Subject: Stitches And Frames The Square Angmering BN16 4EA - A/197/21/PL

Planning Application reference: A/197/21/PL

Proposal: Change of use of vacant retail shop to restaurant to include the installation of new kitchen extraction system, AC condensers, new windows, awning, planters. This application affects the character & appearance of the Angmering Conservation Area & is in CIL Zone 2 (Zero Rated) as other development.

Indicative Specification  
in Plan View Only

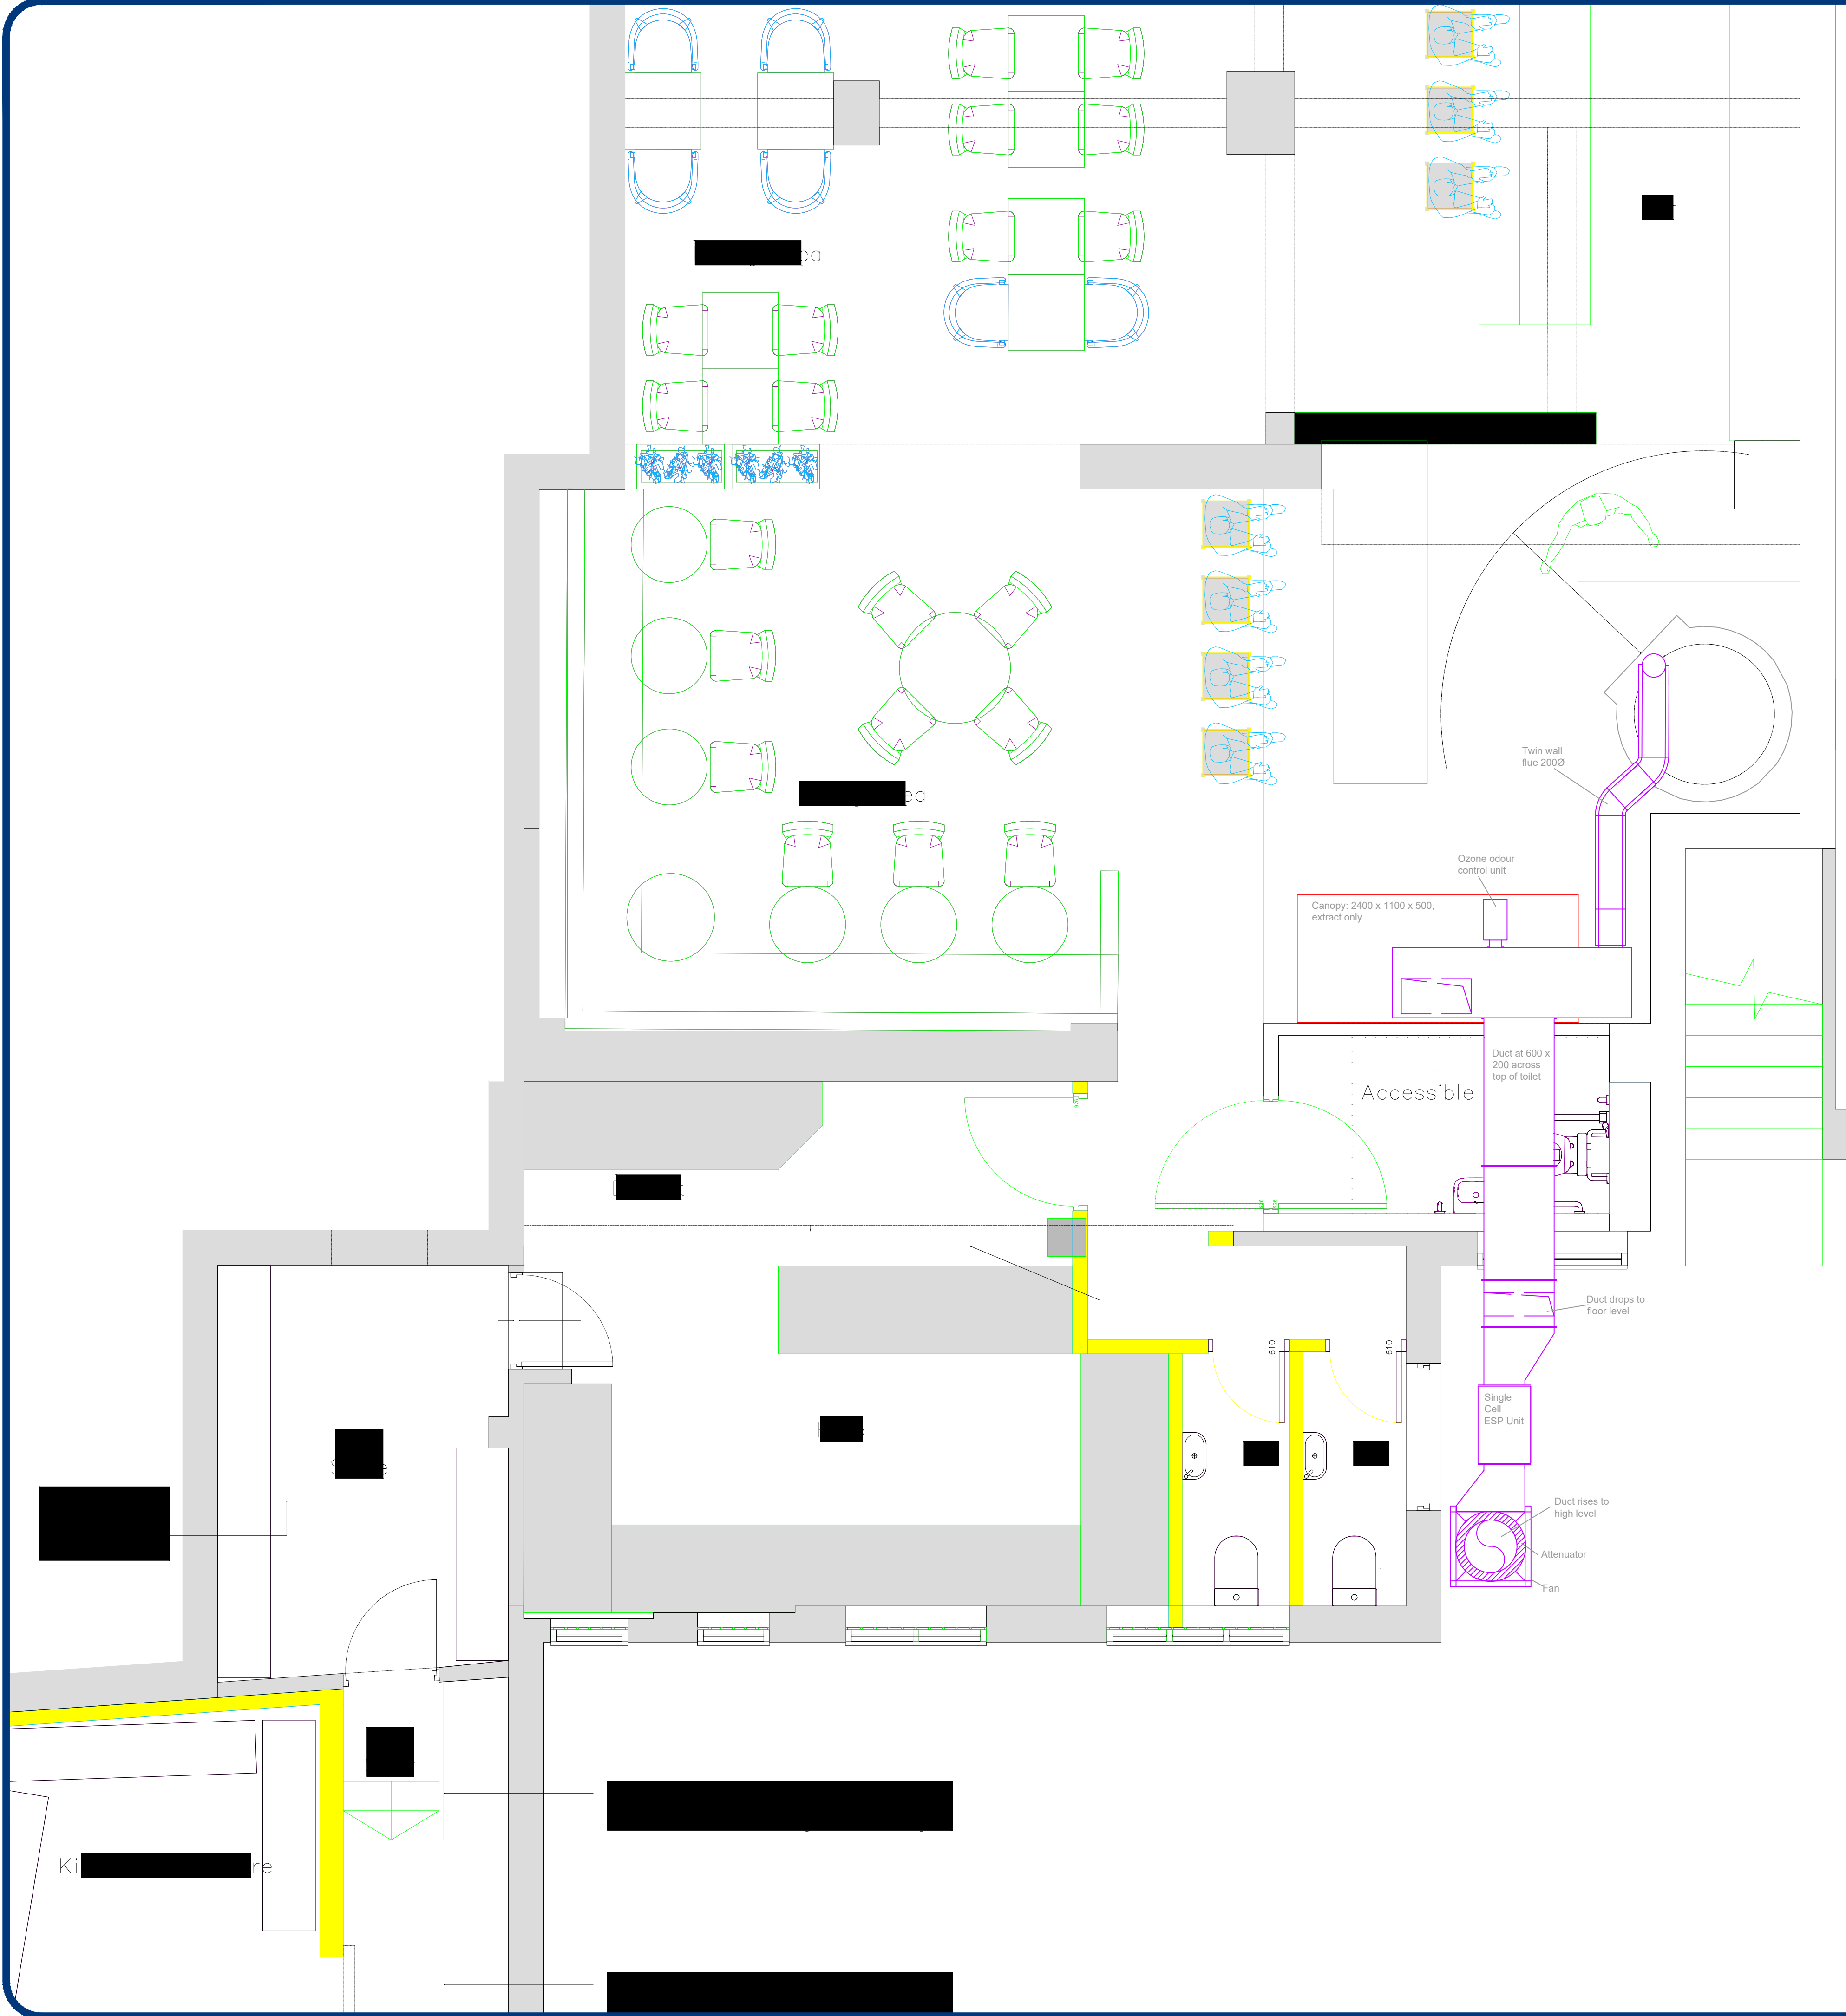
Having reviewed the documents entitled 'The Stone Room, Angmering System Overview' (dated 7th September 21) [produced by BWF] and the drawing entitled 'Indicative Specification in Plan View Only: Drawing No. 20633' (no date) [produced by BWF], I find the proposed extraction system to be in accordance with DEFRA 2005 'Guidance on the Control of Noise and Odour from Commercial Kitchen Exhaust Systems and EMAQ 2018 update'. I therefore recommend that any future permission granted is in accordance with the BWF report and drawing number 20633.
